27th April 2017
Our Ref: DW/Gavray/MP/270417

**15/00837/OUT | OUTLINE - Residential development of up to 180 dwellings,
Part Land On The North East Side Of Gavray Drive Bicester**

Gavray Drive East EDP offsetting calculator review

Gavray Drive East - Illustrative Masterplan  
Sketch of General Parameters  
1:2,000@A1 / 1:4,000@A3

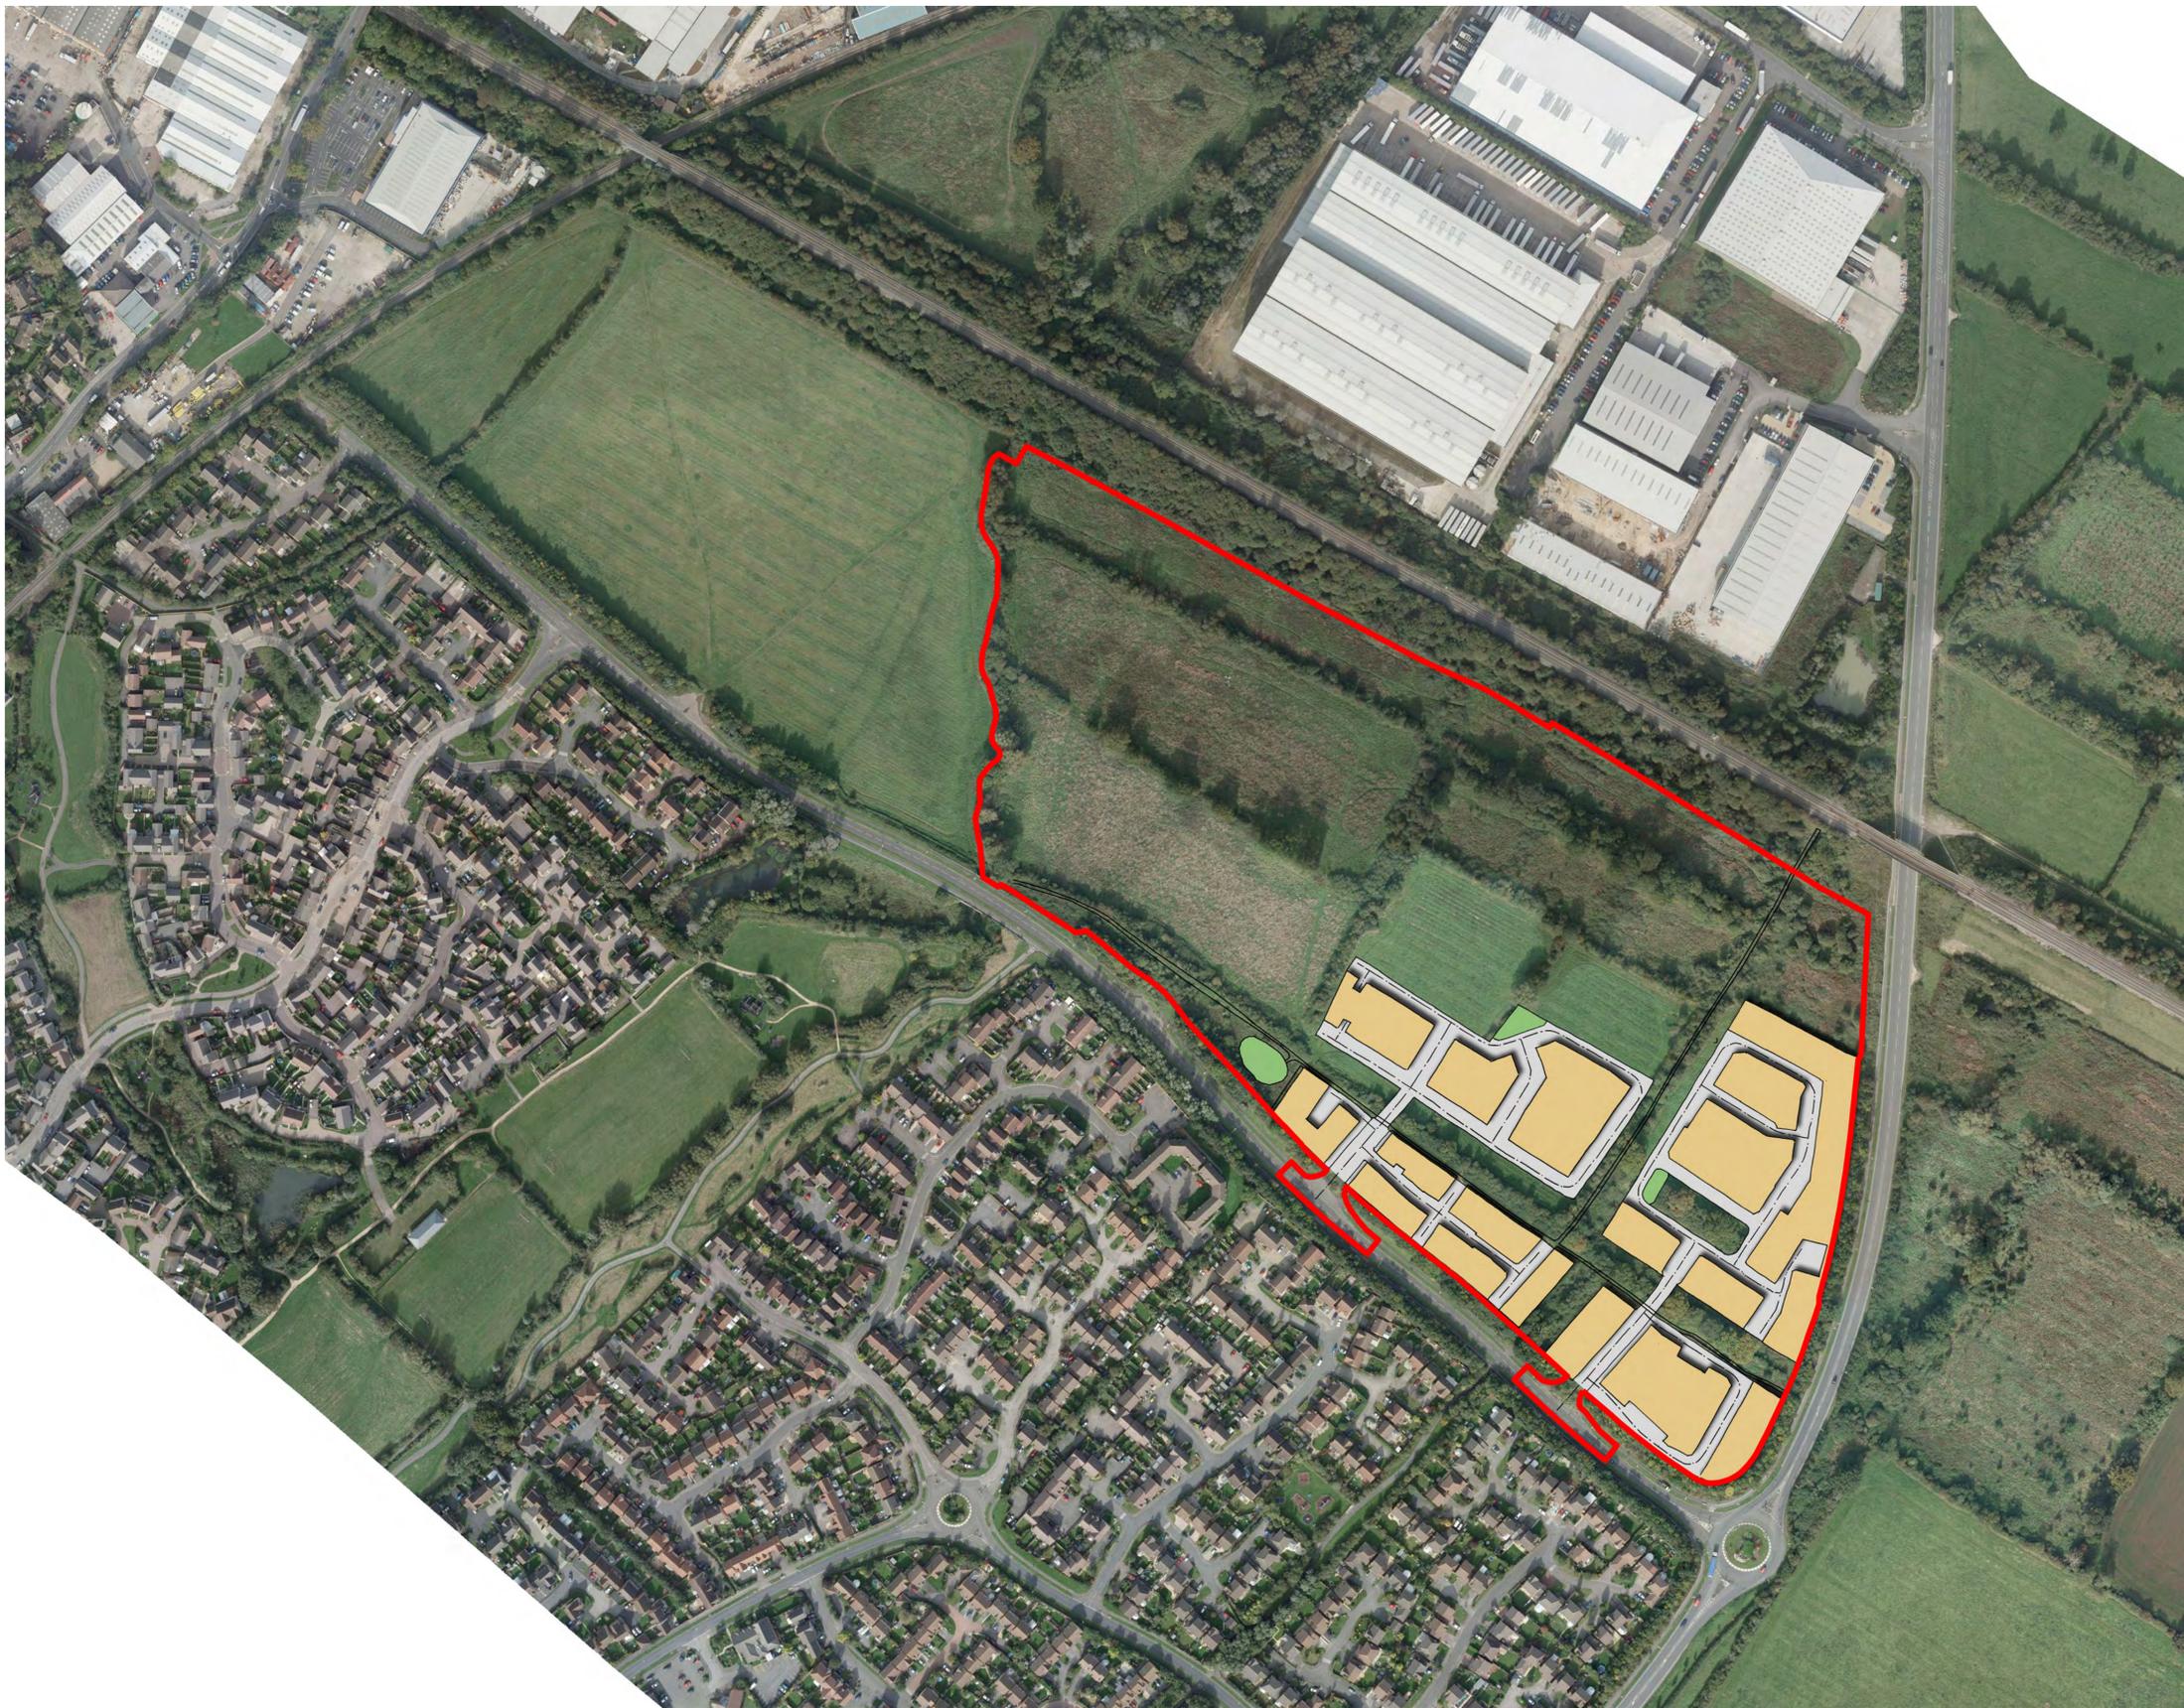
For similar reasons as set out above, the indicative masterplan for Gavray Drive East submitted by the applicant reveals an intention to build on effectively all of the area for which Councillors voted to pursue Local Green Space designation (as against that already protected as Local Wildlife Site). Thus, granting consent for 15/00837/OUT will set up a situation where this commitment, duly voted upon by Councillors, and which is still outstanding and patently not forgotten by local people, becomes impossible to deliver.

Of the land to be used for development (8.18ha of the site), a figure of 3.15 ha has been input as 'unimproved neutral grassland' of moderate condition deliverable in 10 years. With reference to the masterplan for Gavray East submitted in support of the calculator on 12/04/17, where is this 3.15ha proposed to go? I note that there is no provision for amenity grassland of the type that would be expected to provide recreational open space, so one must assume that the unimproved grassland is expected to perform a dual function hard-wearing amenity uses, and sensitive, high distinctiveness wildlife habitat, all over the course of its creation and establishment from a standing start to the point at ten years where it is cited to be in moderate condition. The nonsense in such assumptions is self-evident to anyone with even the most basic appreciation of unimproved grassland habitats of high distinctiveness. The applicant provides no empirical evidence of delivery of unimproved grassland habitat of equivalent value to that under threat at this site within this timescale and secondly provides no evidence or case studies demonstrating where open space provision in a development has successfully been reconciled with management as unimproved grassland.

No significant provision for creation of amenity open space is made. Unimproved neutral grassland will not be able to absorb open space pressures. Taking account of the need for formal play space there would thus appear to be no provision for delivery of the open space standards required to be delivered by Policy BSC10 etc in the Cherwell Local Plan. Furthermore, it exposes the intention that the LWS is intended to be used to absorb the open space demands of the development at Gavray Drive East. This would be incompatible with its proper management in order to deliver the stated enhancements, and is more likely to give rise to net negative effects, which we note have not been quantified in the calculator.

The figure for 'area of built development' on the calculator is 3.49ha. Only 3ha is required to achieve 120 units at a standard density of 40 dph.
